**RE: Lot 2 Executive Hills 2
700 Winterwood Pl. SE
Grading and Drainage Plan
Engineers Stamp Date 3/17/22
File Number (L23D038)**

Based upon the information provided in your submittal received 3/21/22, this plan cannot be approved for grading permit until the following comments are addressed.

GRADING PLAN

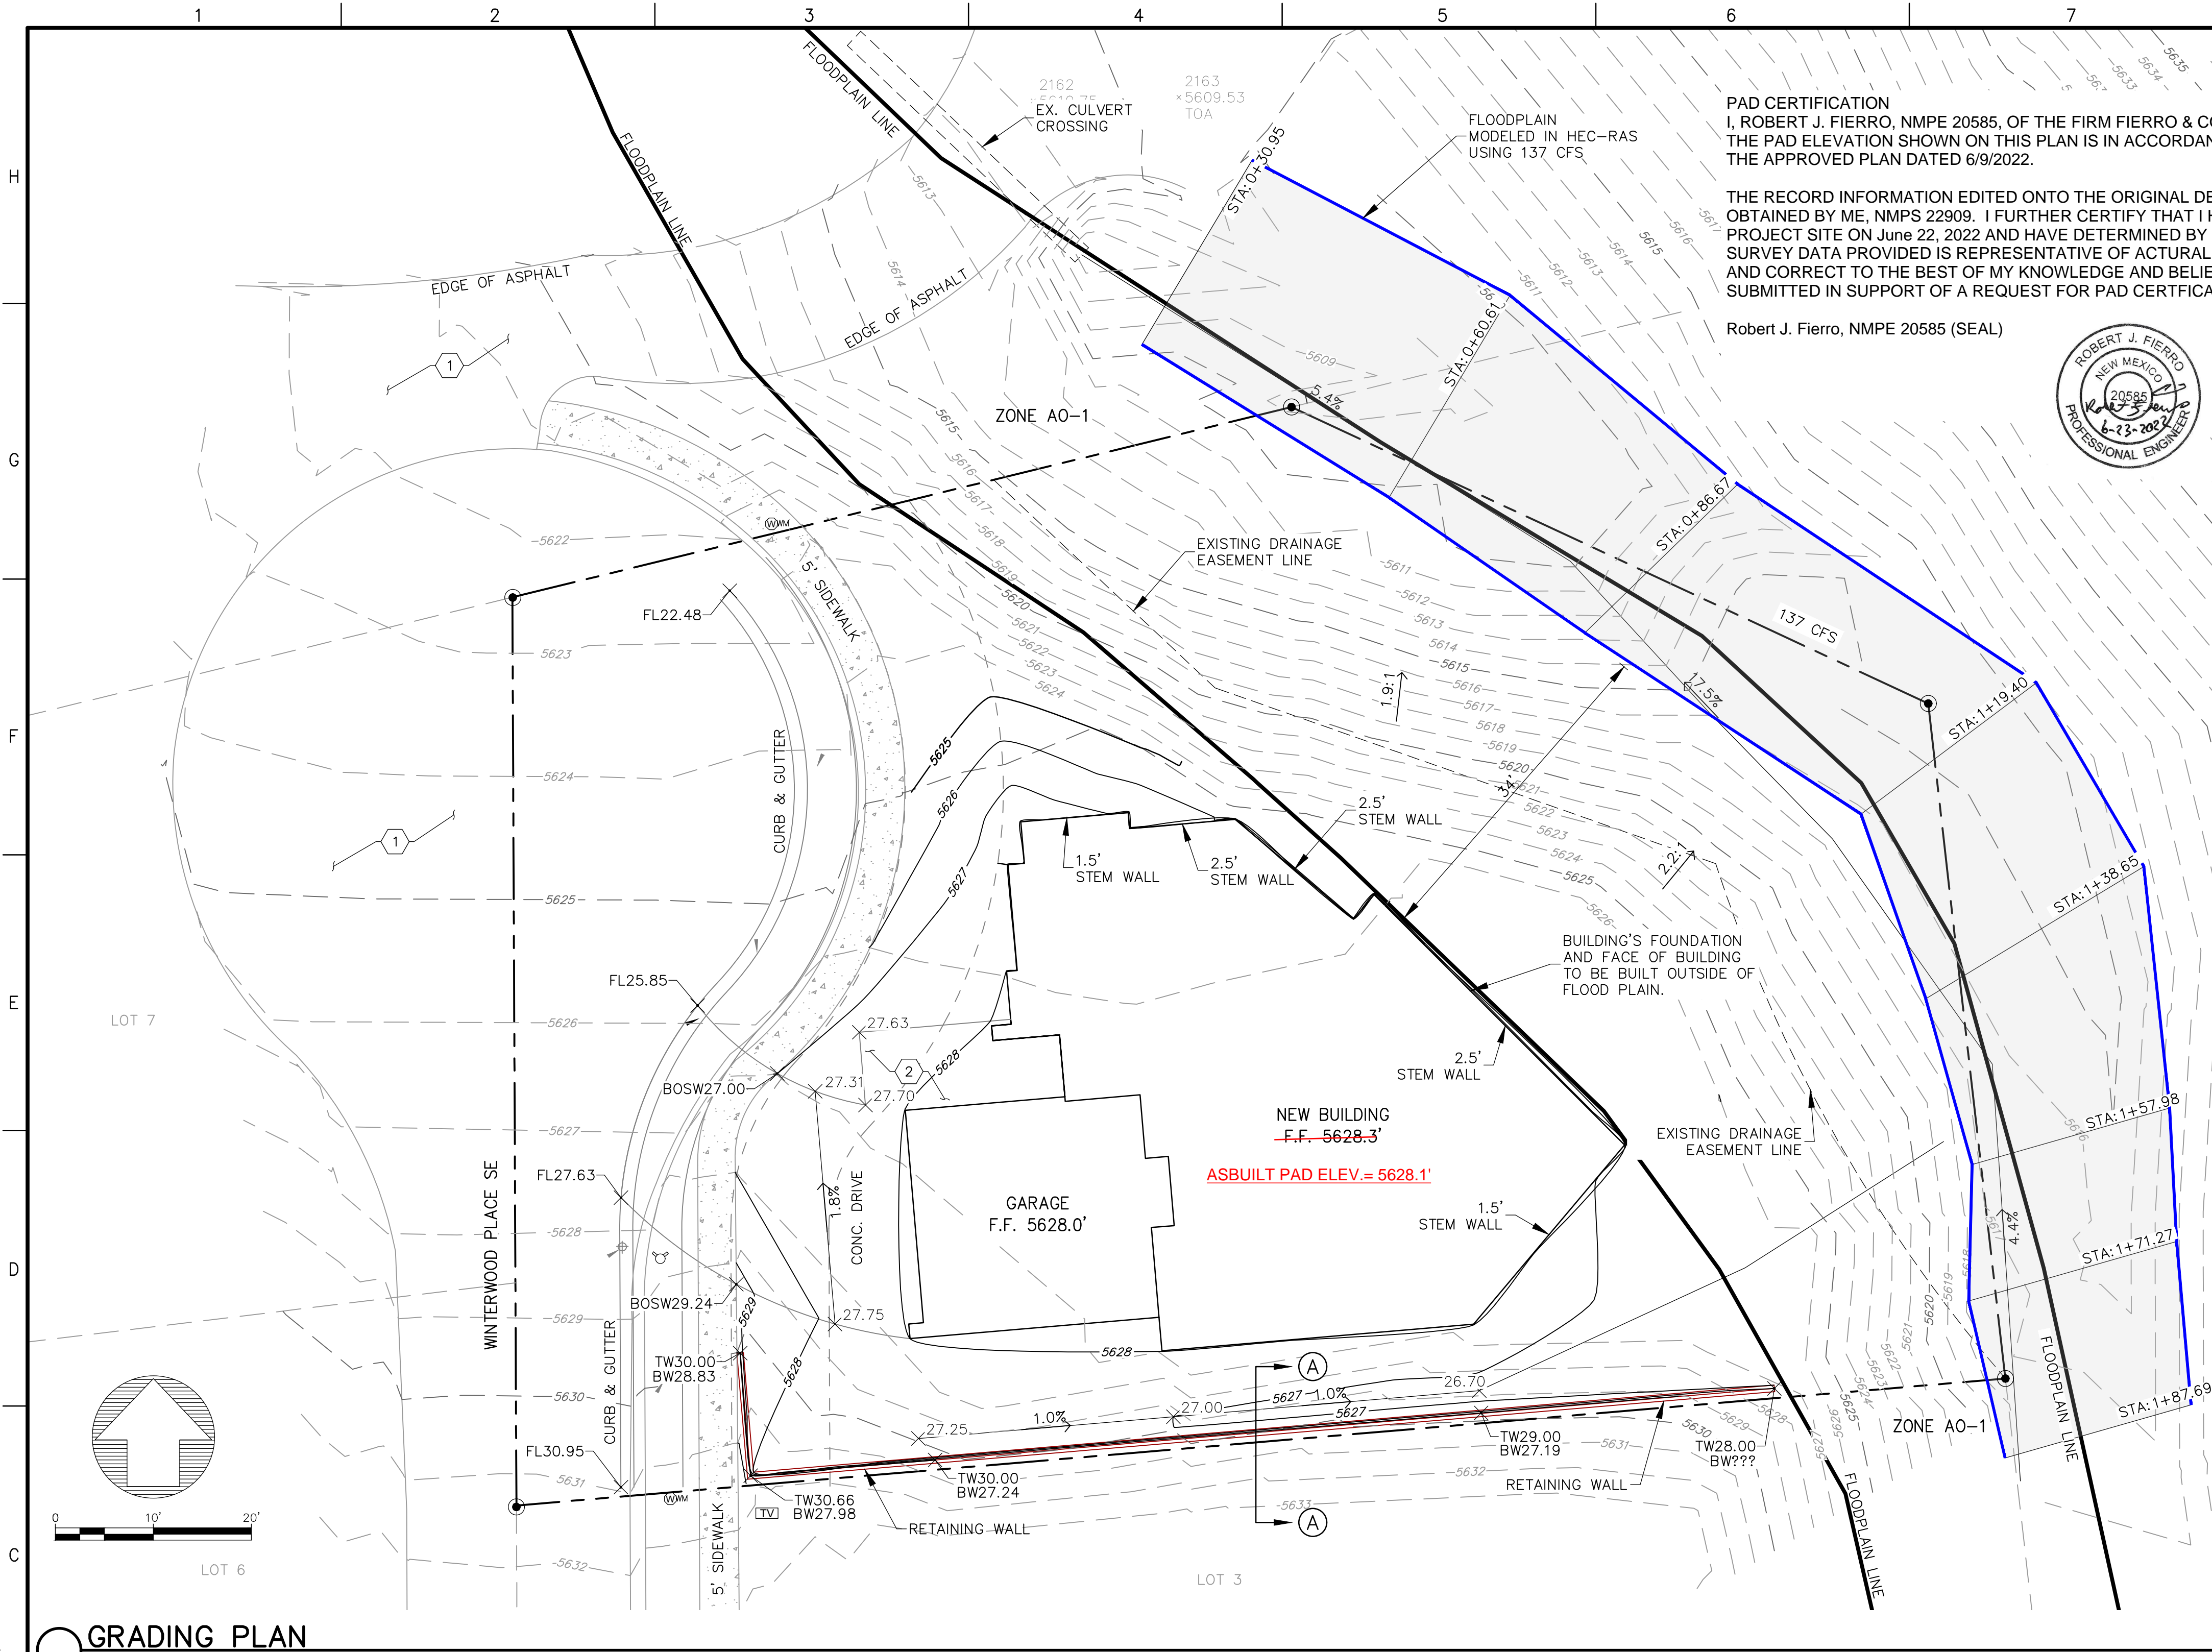
1. A portion of this site is located in a floodplain (AO-1') and a floodplain development permit must be obtained if any portion of the structure falls within the floodplain. The permit application must demonstrate zero rise to the base flood elevation, unless a Letter of Map Revision (LOMR) is being prepared. Please contact Rudy Rael, CFM for more information regarding floodplain development permits (rrael@cabq.gov or 924-3977). Please show the floodplain on your plans.

2. Per the DPM, the following must be on the Grading Plan.
 - a. Please provide an engineer's stamp with a signature and date.
 - b. Please use 1" = 20' for the scale.

- c. Please provide a Vicinity Map.
 - d. Please provide the Benchmark information (location, description and elevation) for the survey contour information provided.

- e. Please provide the FIRM Map and flood plain note with effective date.
 - f. Please provide a legal Description of the property.

3. Please provide a vicinity map showing the location of the site. Typically this is the Zone Atlas. This can be downloaded in pdf format from the City of Albuquerque's website.

4. It appears that your engineering stamp is too big. The NM Board of Licensure for Professional Engineers and Professional Surveyors Administrative Code 16.39.3.12.C states, "The design of the seal/stamp shall consist of three (3) concentric circles, the outermost circle being one (1) and one-half (1/2) inches in diameter..."

5. Per the DPM Chapter 6 Section 13(C)(1), 24"x36" is currently the City's standard. This applies to all site plans, Grading & Drainage Plans, Traffic Circulation Plans, DRC Plans etc. Please resubmit with this plan size.

DRAINAGE PLAN

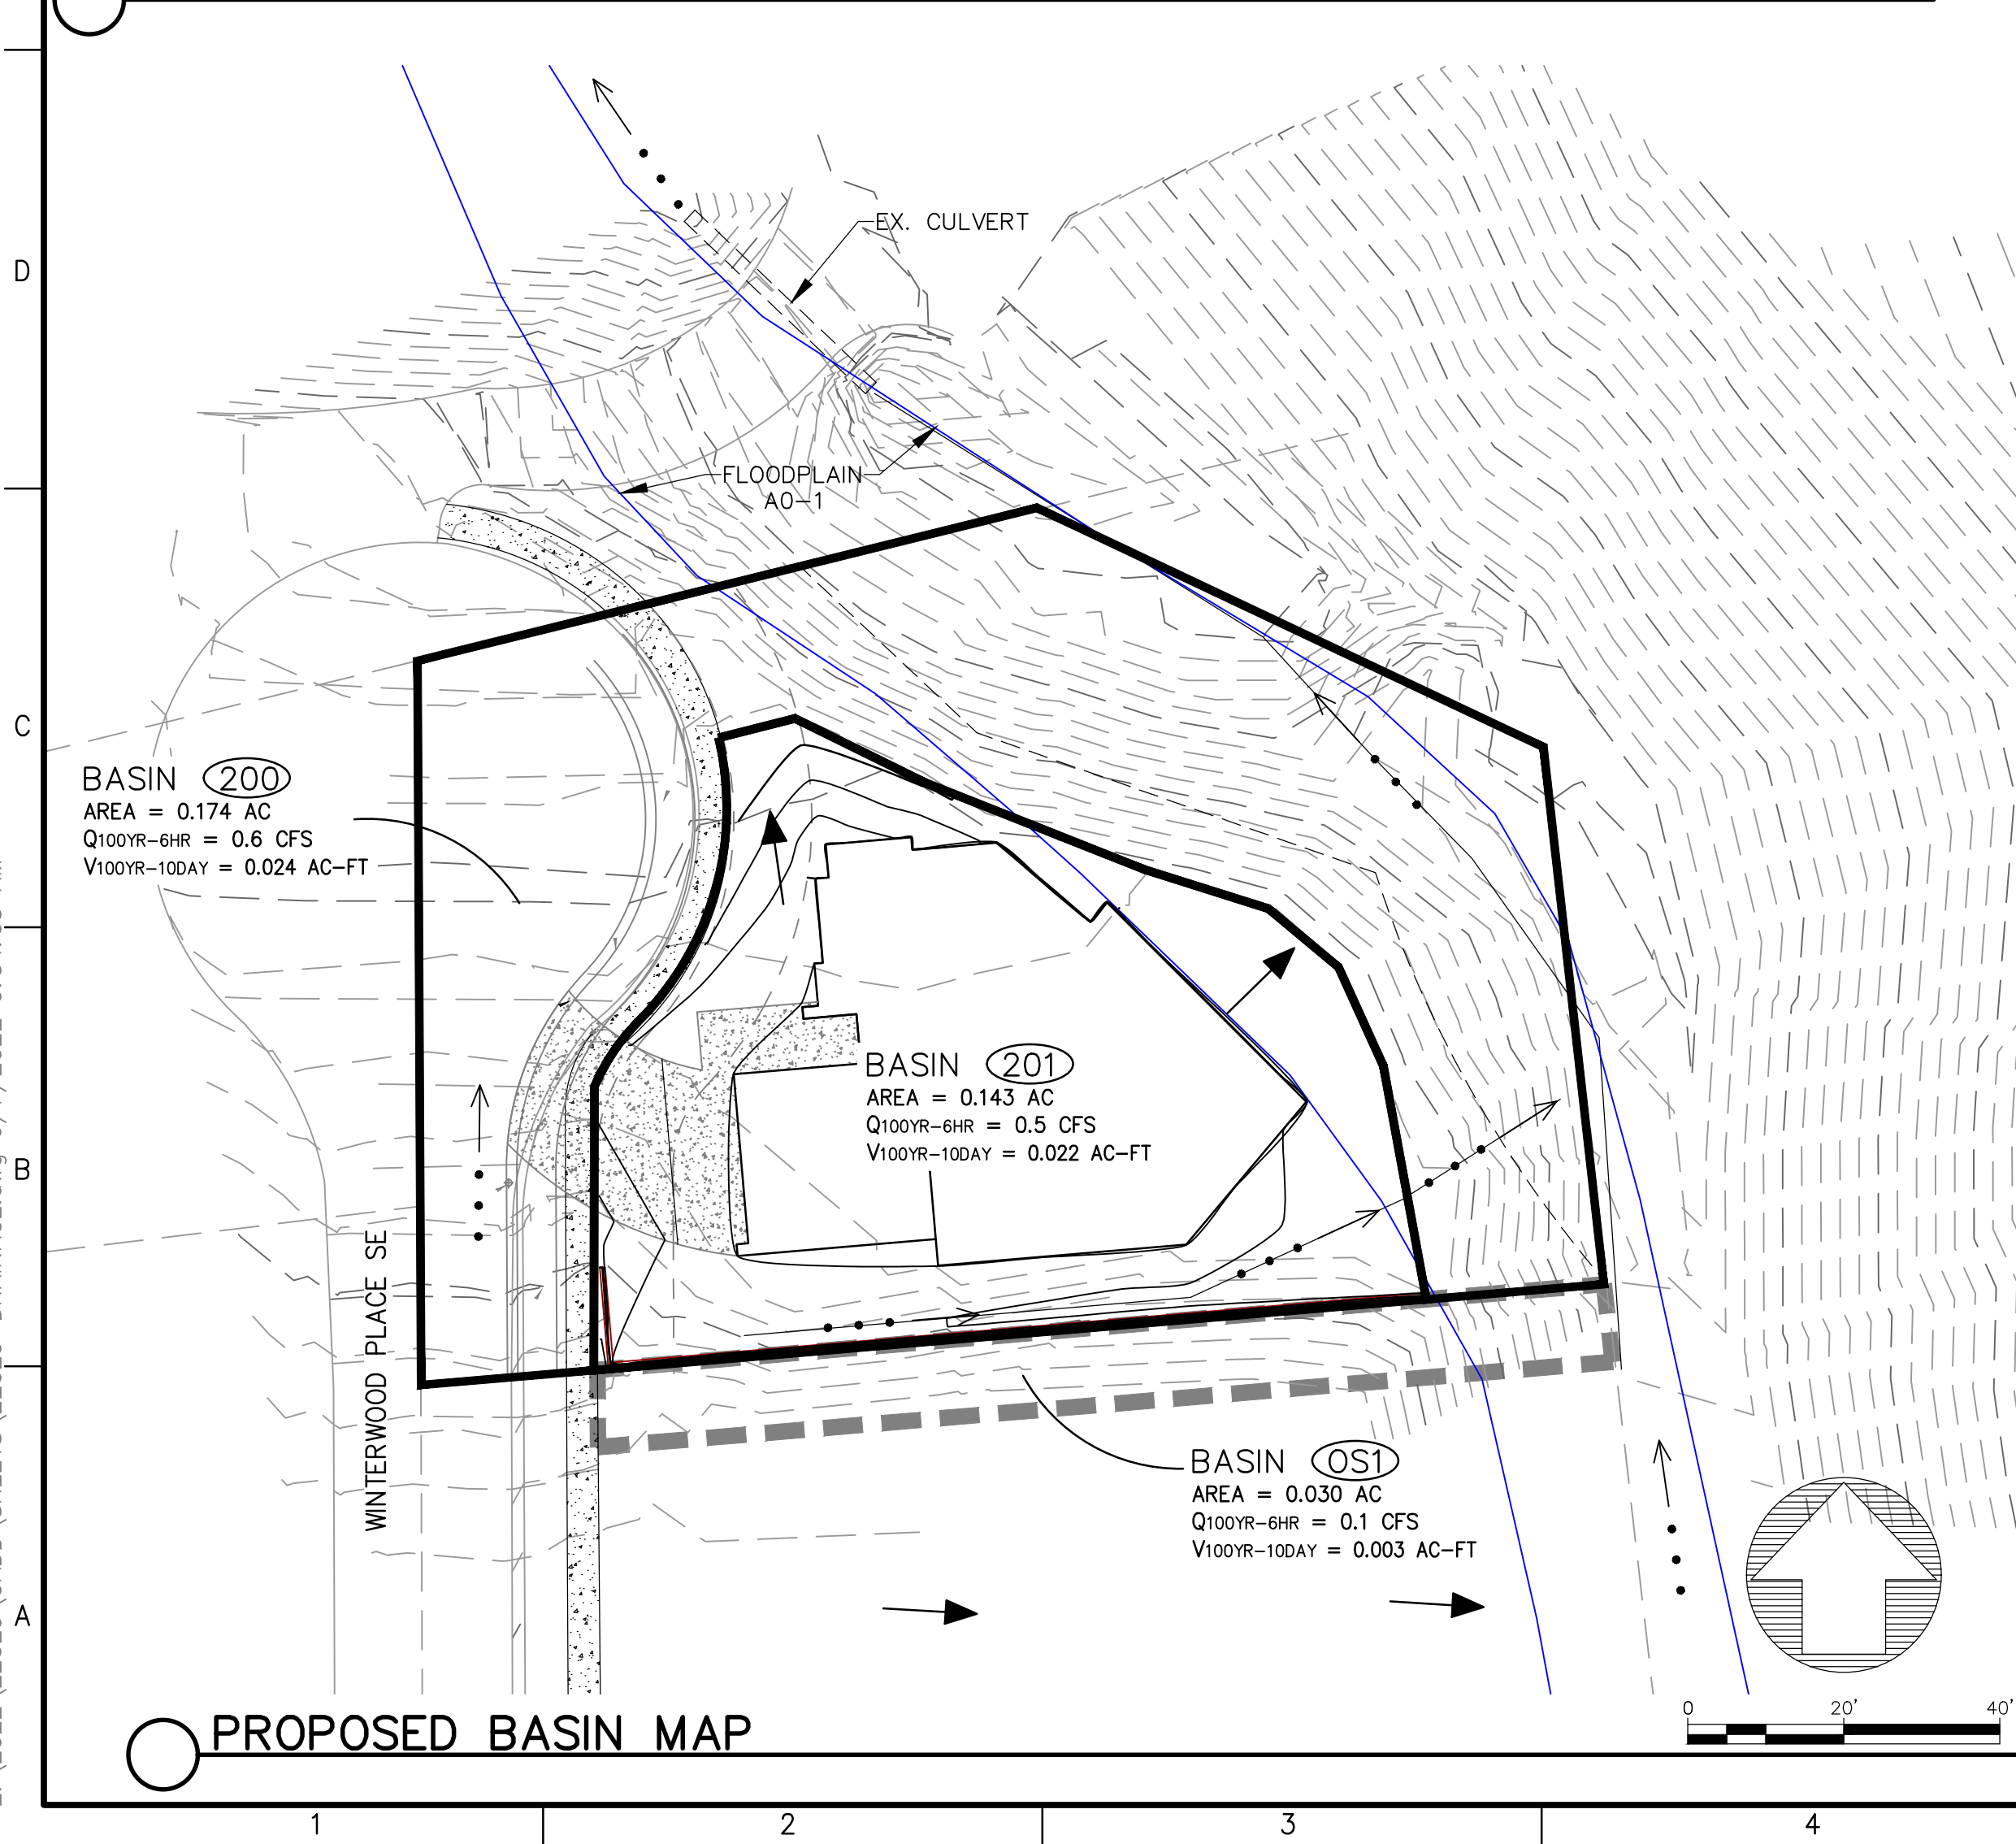
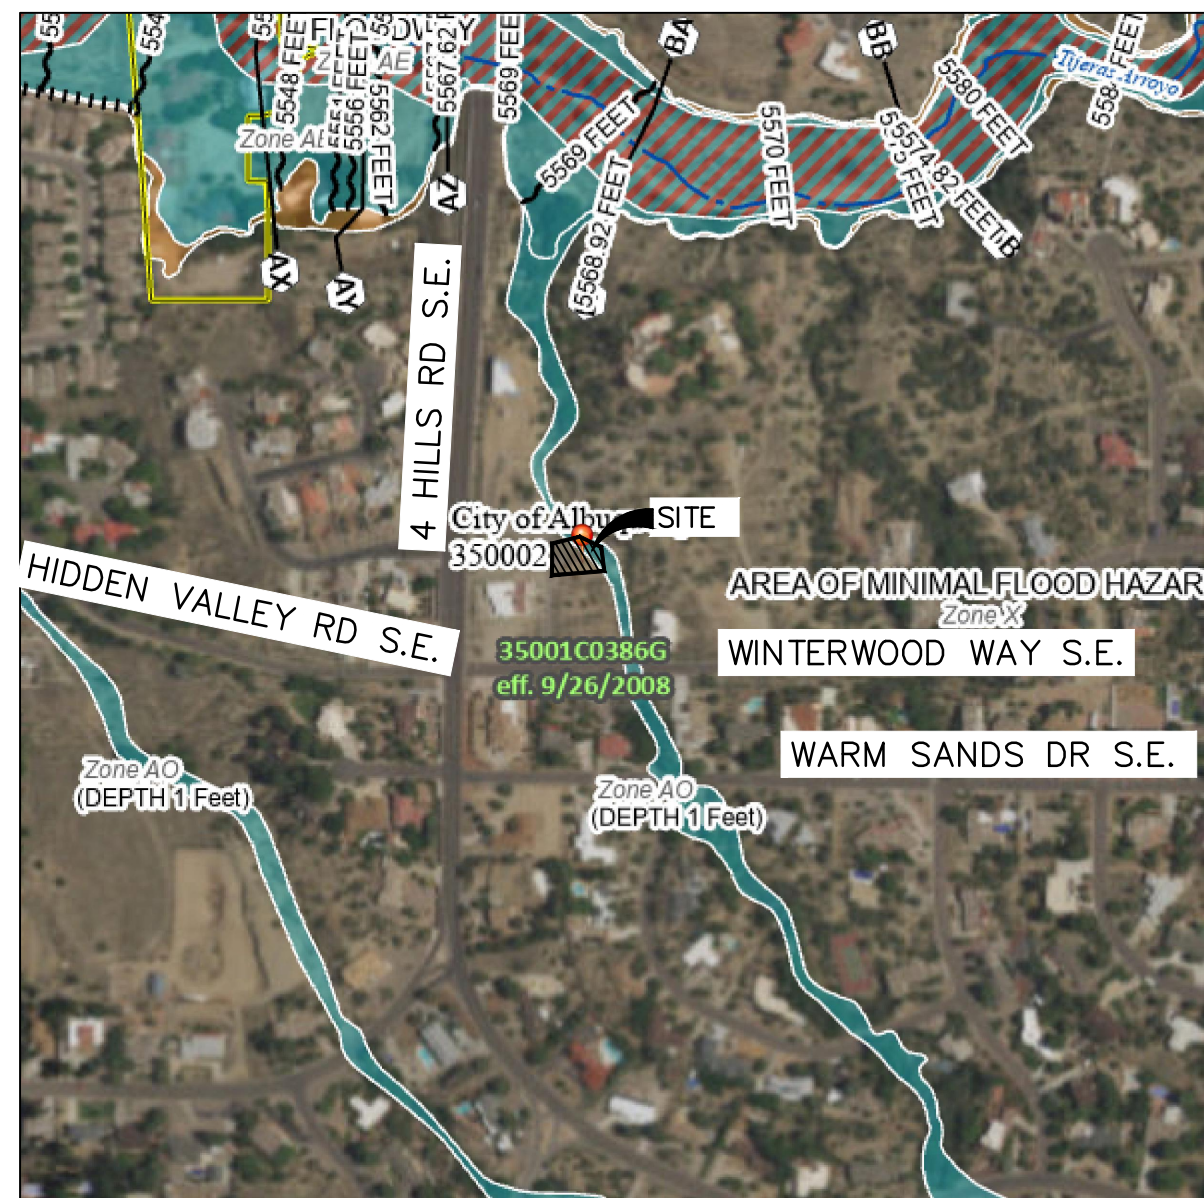
6. Please use the procedure for 40 acre and smaller basins as outlined in Development Process Manual (DPM) (signed 06/08/20) Article 6-2(A). Please provide both the existing conditions and proposed conditions for the 100 year-6 hour storm event.
